# City of Albuquerque

RE: REVISED DRAINAGE PLAN FOR EXPANSION OF BUILDING 21-A  
GENERAL ELECTRIC NORTH PLANT (M-14/917 *DGE*)  
ENGINEER'S STAMP DATED JUNE 11, 1990

Re: Grading and Drainage Plan for Expansion of Bldg. 21A  
General Electric North Plant (M-14/~~0070~~)  
Our Project #89-05-05 *DGE*

RE: DRAINAGE PLAN FOR EXPANSION OF BUILDING 21-A  
GENERAL ELECTRIC NORTH PLANT (M-14~~1002/1000~~)  
ENGINEER'S STAMP DATED MAY 16, 1990

GRADING AND DRAINAGE PLAN

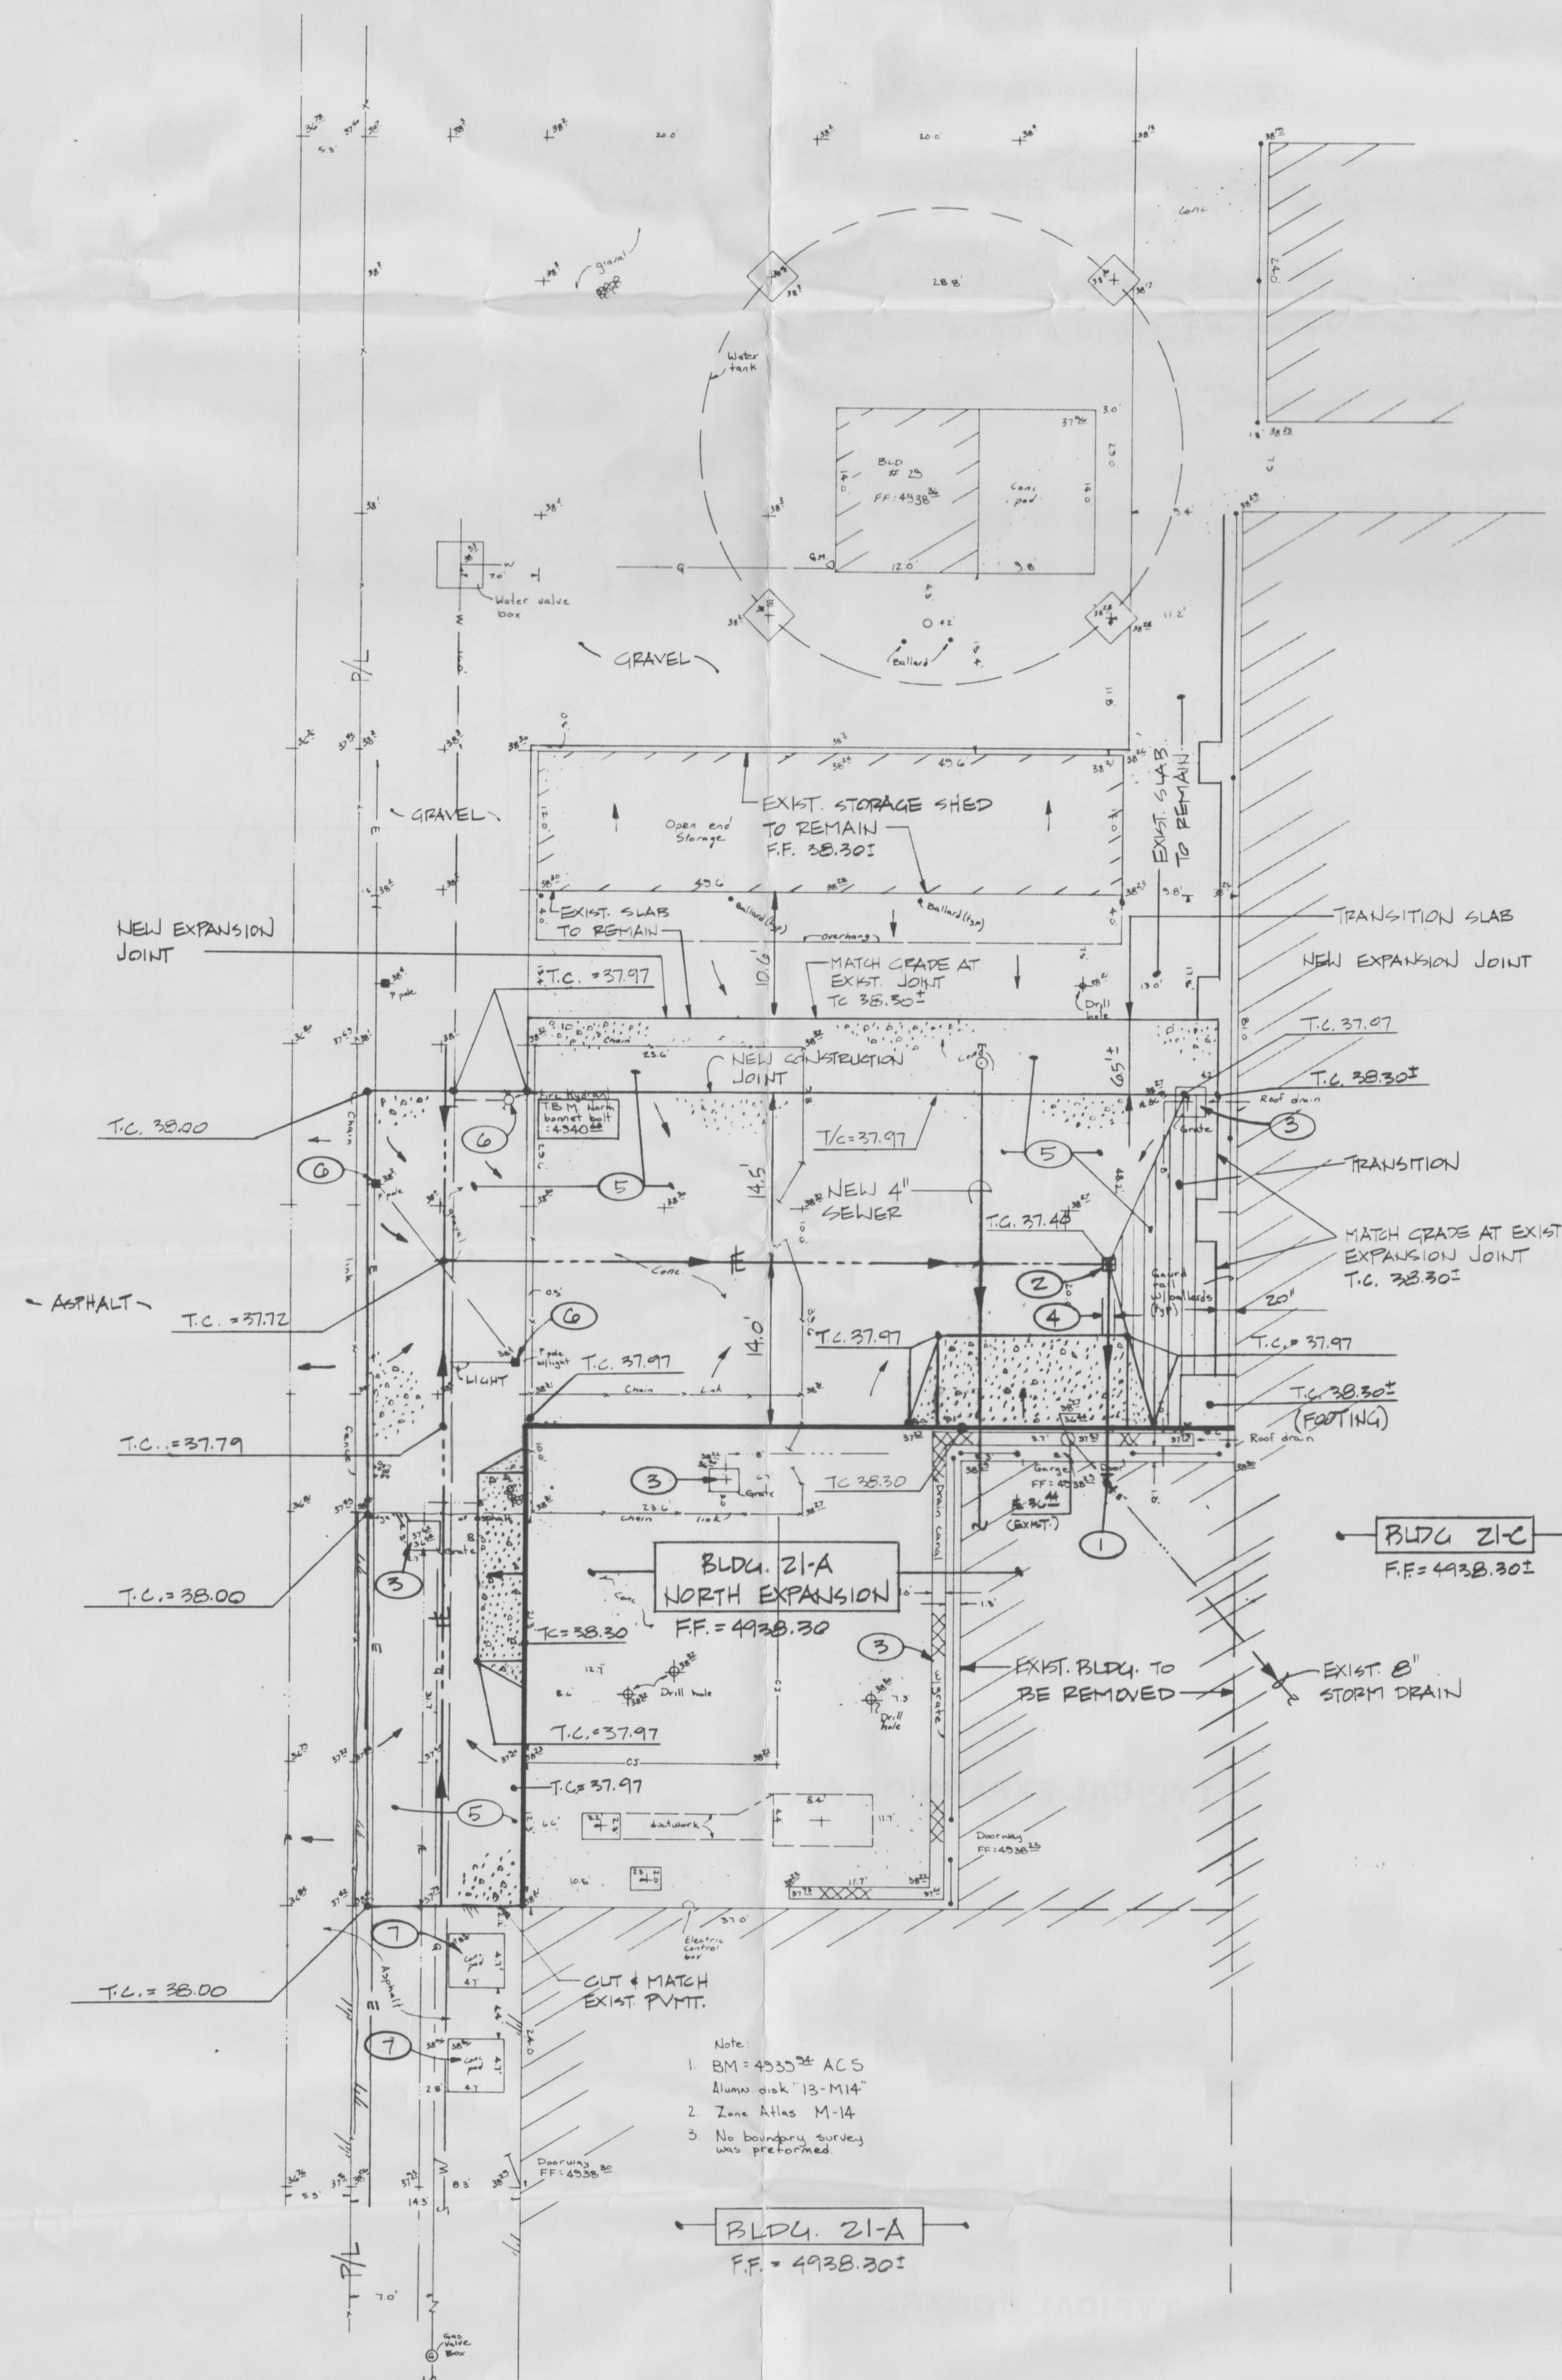
Based on the information provided on your resubmittal dated June 13, 1990, the referenced drainage plan is approved for building permit.

1. You must include your existing and proposed flow rates even if there is no change.
2. Please include the legal description within the plan drawing.
3. The "Preliminary Not For Construction" note must be removed. The drainage plan, when and if approved, is for construction purposes.
4. Any further improvements will require a Master Drainage Plan for review.

1. The existing and proposed flow rates are included on the Grading and Drainage Plan.
2. The legal description is now included on the plan.
3. The "Preliminary: Not for Construction" note has been removed.
4. Smith-Scheuch Engineering Company (S-SEC) will advise General Electric that further improvements will require a Master Drainage Plan for review.

In addition to our response to your comments, we would like to advise you that the Owner has requested that the compressor building not be constructed at this time. This change is reflected on our current Grading and Drainage Plan submittal dated June 11, 1990. The deletion of this building will not affect the runoff volume and the storm sewer improvements will remain the same as in the initial Grading and Drainage Plan.
